From: [REDACTED]
Sent: 14 September 2021 14:02
To: Maria Tomalova <Maria.Tomalova@arun.gov.uk>
Subject: RE: BR/119/21/PL

Subject: BR/119/21/PL

Component: Proposed Site Plan - Ground Floor

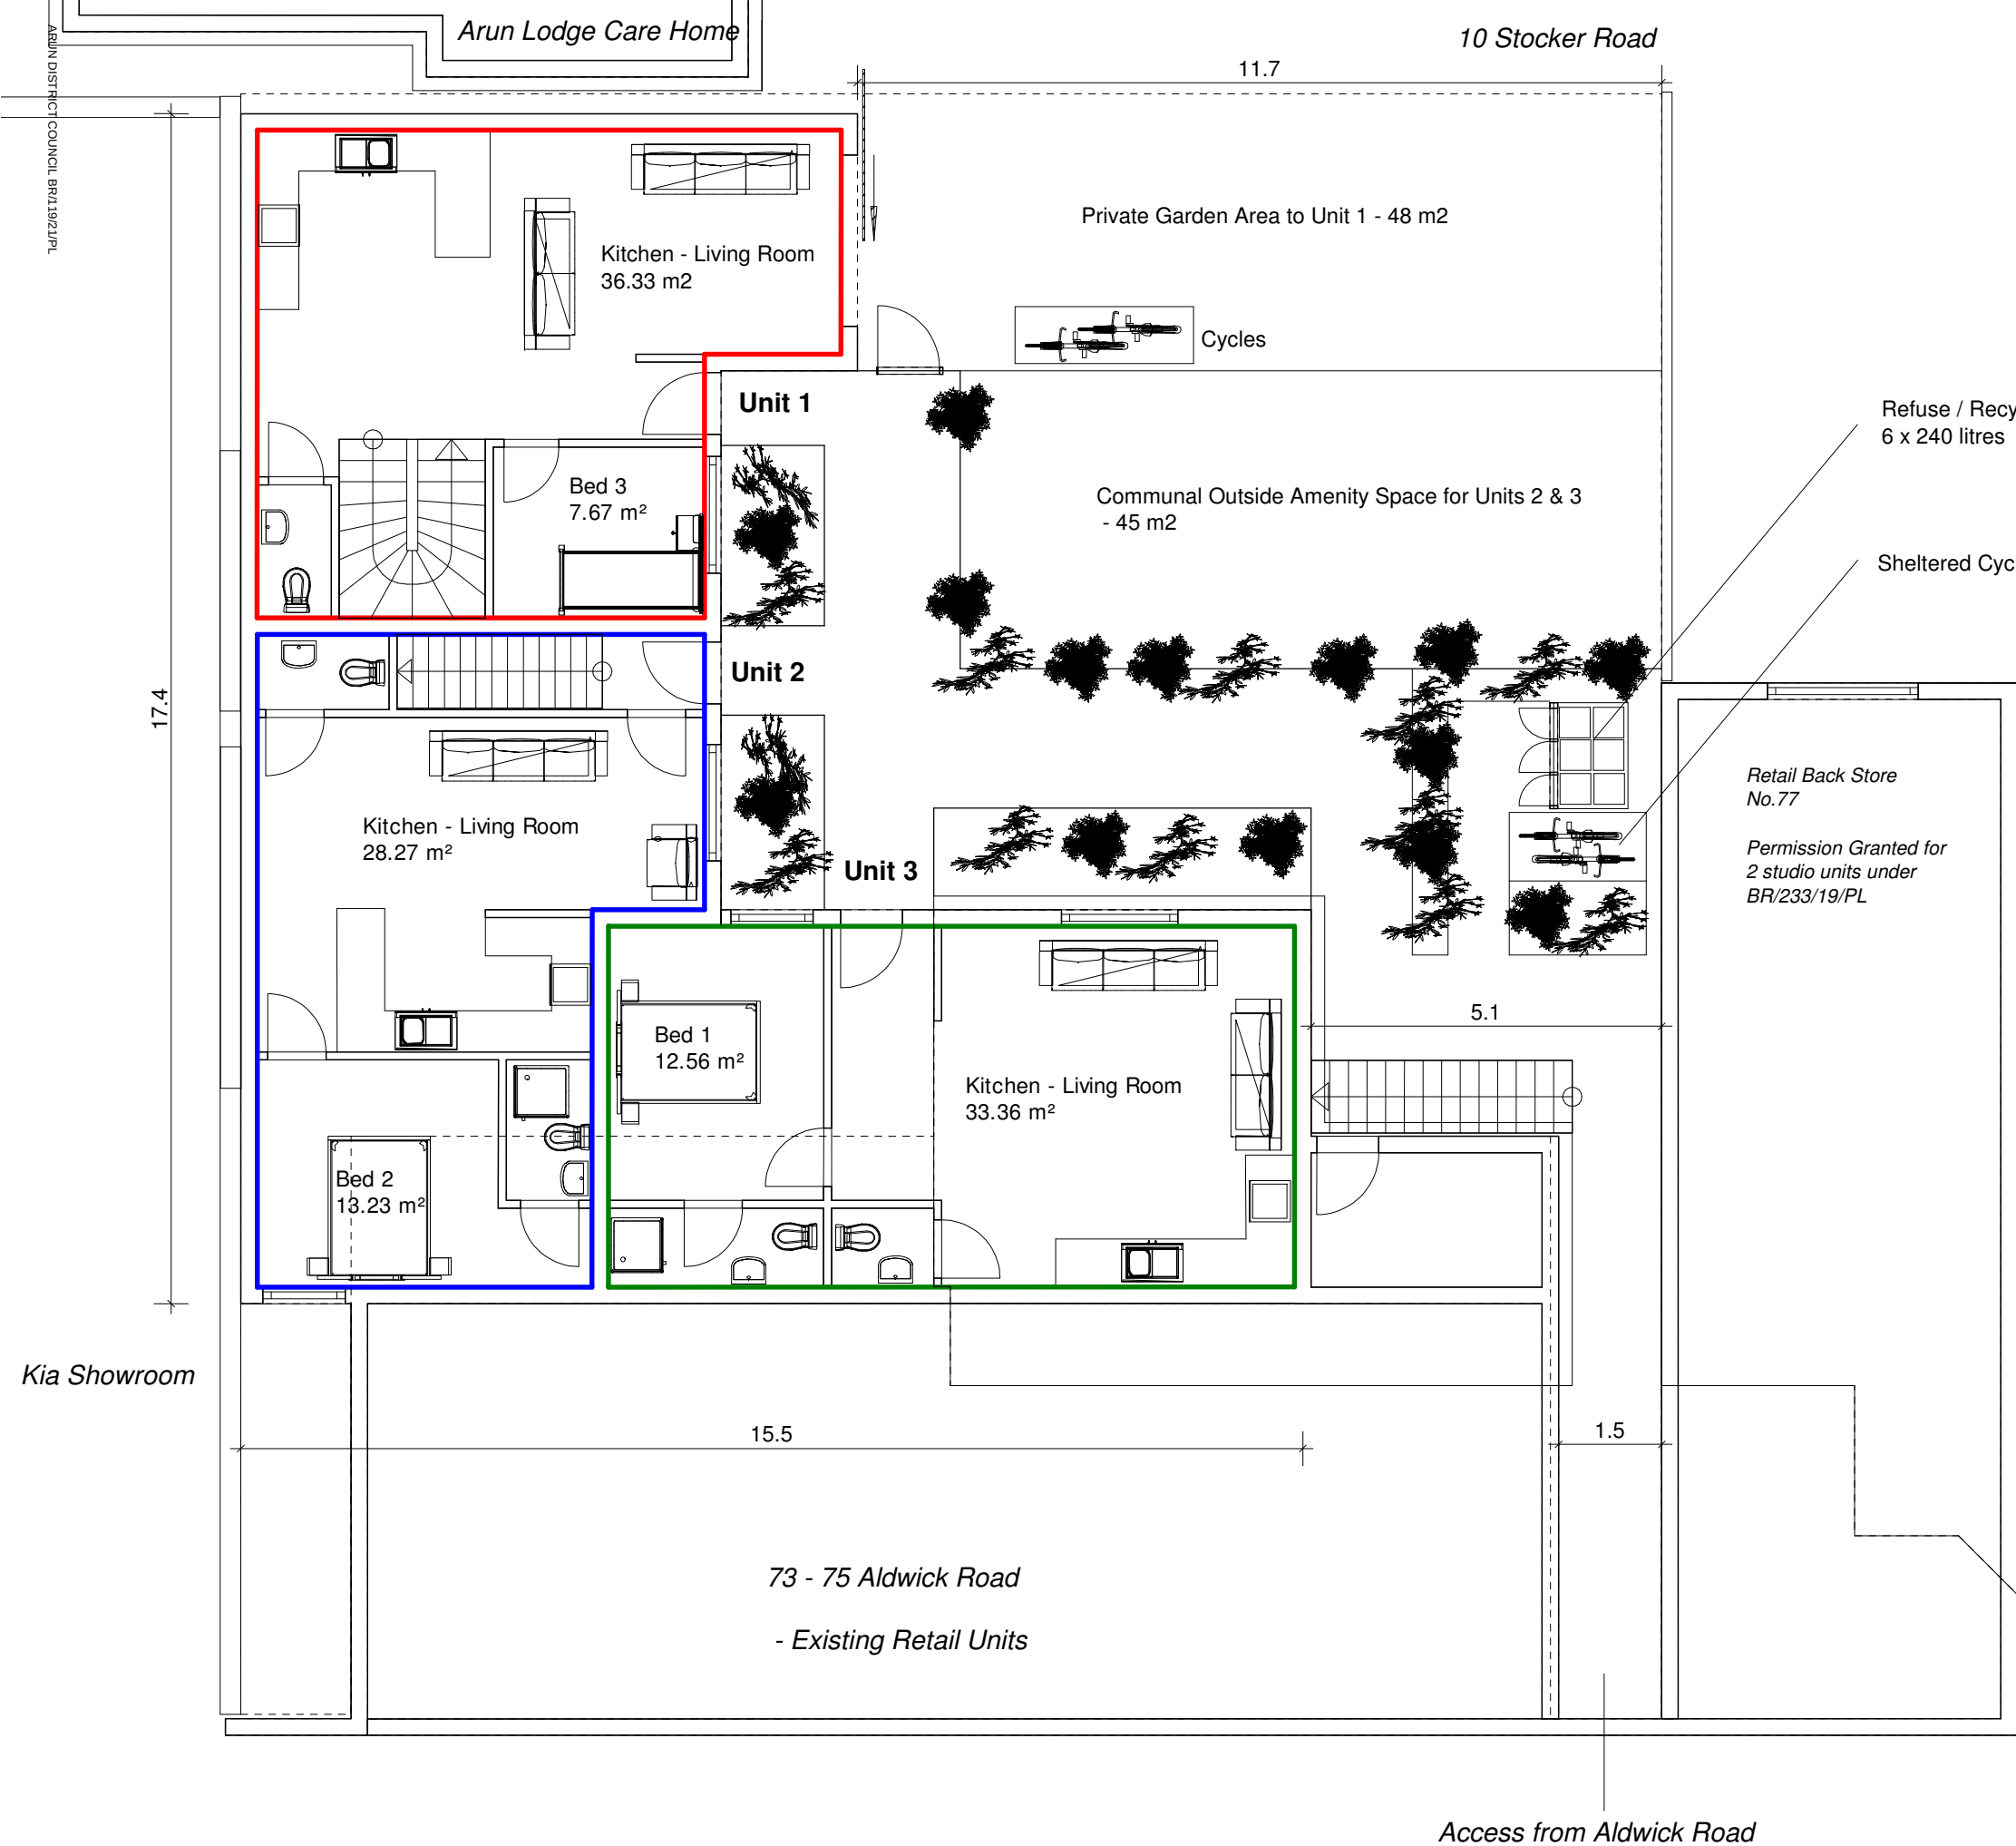
What you are proposing is not a mews but an inappropriate extension.

The proposed rear extension would visually dominate an existing building its immediate surroundings.

Its design fails to reflect the style of host building (there was a confusion if the proposed is an extension or an another building attached to the rear

The extension would rise above the penultimate storey of an existing building.

It would occupy an extensive part of the yard.

It would upset the proportion of an existing building.

Would be visually intrusive/unsightly when seen in longer public or private views from ground and upper levels.

The rear garden of No 10 Stocker Road would be observed from the first floor windows of proposed with a distance of 7m.

The existing terrace and balcony of an host building would be overlooked from the first floor windows as well.

The living condition of prospective occupiers: Bed 2 of 2bed unit above 2 floors would be lit through the well between 73 and 71 with no outlook and proper ventilation (Fire escape?).

The applicant should be aware that our mapping indicates that the foul sewer crosses the site in the vicinity of the proposed extension, please consult Southern Water regarding this.'
